**Re: Response to Request for Information
SSD-71454709 MOD 1
Mixed-use Development including Affordable Housing
30-34 Padstow Parade & 10 Faraday Road, Padstow**

Table 1: Response to Council Comments

Swept Path Analysis
Ground Floor
Passing Opportunity for Egressing vehicle
B99 Design Vehicle Passing a B85 Design Vehicle

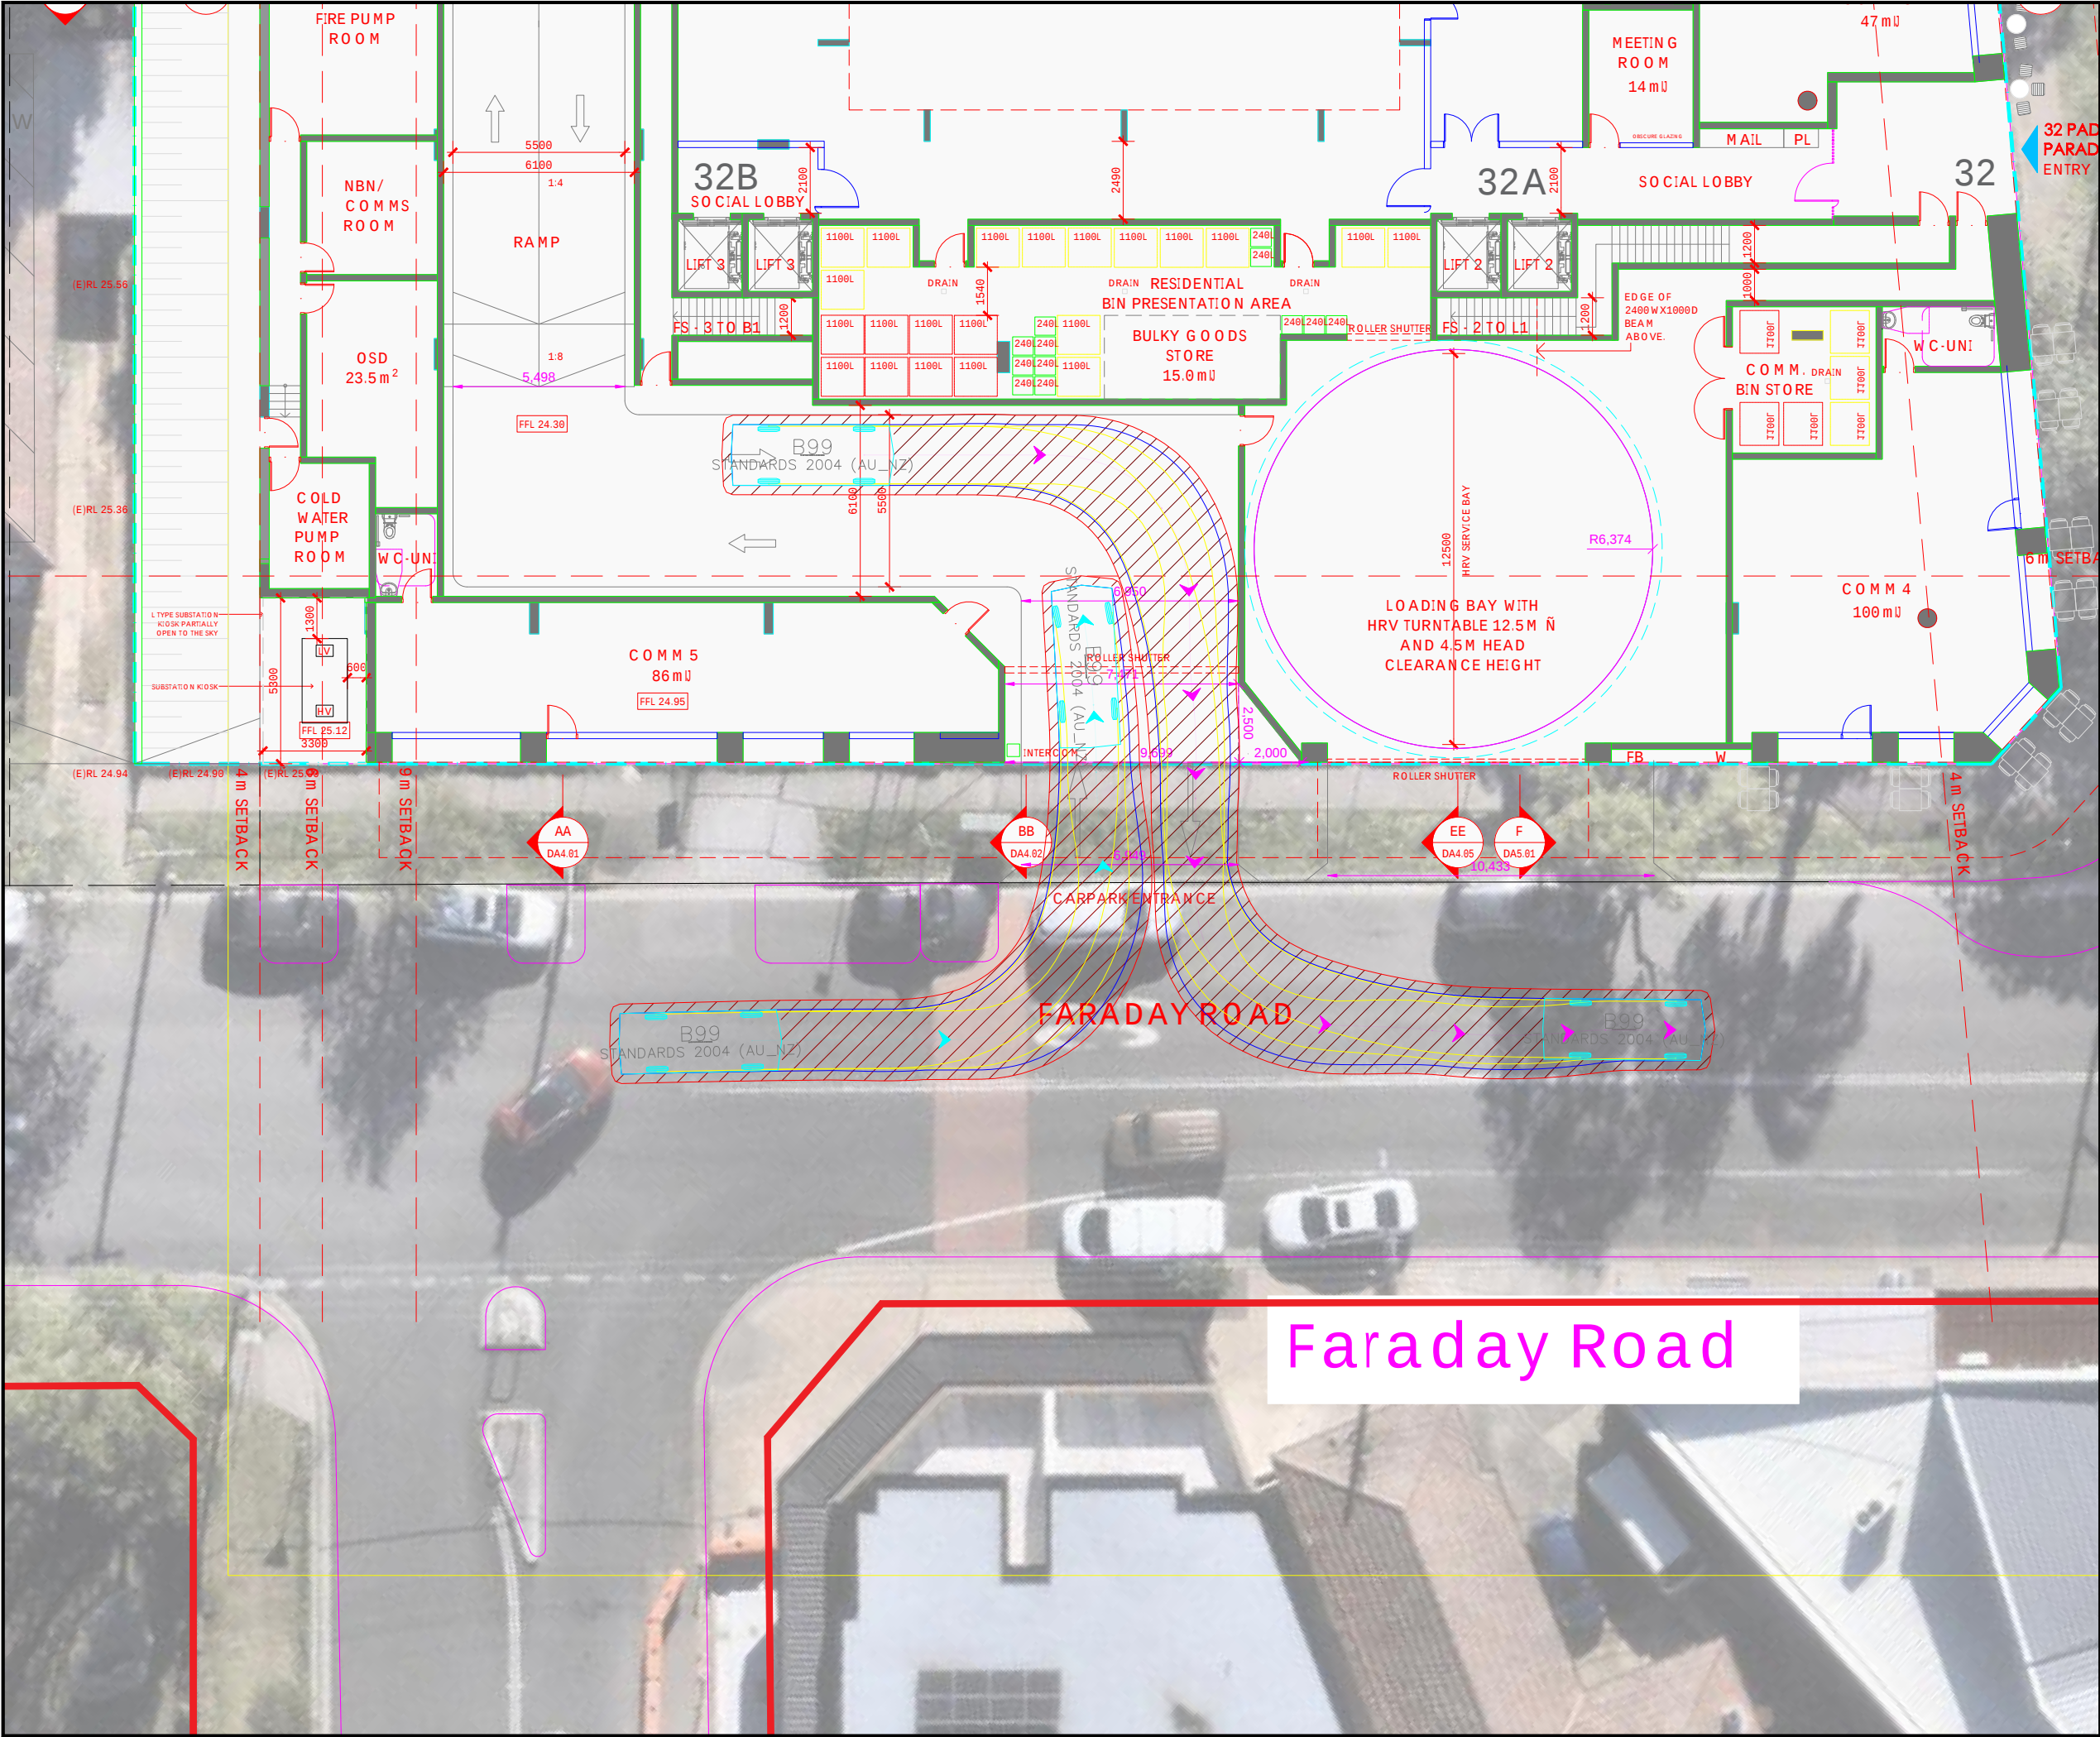
- The traffic report has failed to provide details on traffic management between the VFC and basement ramp on the ground level and the traffic measures to be implemented to manage two-way traffic flow being funnelled into a one-way circulation roadway.
- The proposed tree planting near the proposed carpark VFC shall be removed to allow for better manoeuvrability of B99 vehicles.
- The proposed location of the relocated roller shutter door will result in loss of internal queueing space within the ground floor. Therefore, queueing analysis will need to be conducted to ascertain the impacts along Faraday Road.
- The proposed intercom location is located on the passenger side of vehicles and needs to be located on the driver side.

roadway can still function as two-way in compliance with AS2890.1.

- A convex mirror will also be provided to assist with sighting of on-coming vehicles.
- The swept paths indicate the proposed street tree planting does not impede access to the site and therefore removal of the tree is not required.
- It is now proposed that the roller shutter door at the driveway entrance be kept open during commercial operating hours providing direct access to the basement and therefore no queueing will occur at these times.
- At night the shutter door will be closed but openable by remote control by residents, again ensuring no queueing.
- The intercom therefore will not be needed. Nevertheless, it is proposed to be retained as indicated to cover very rare events where access is required by a person who does not have a remote control.
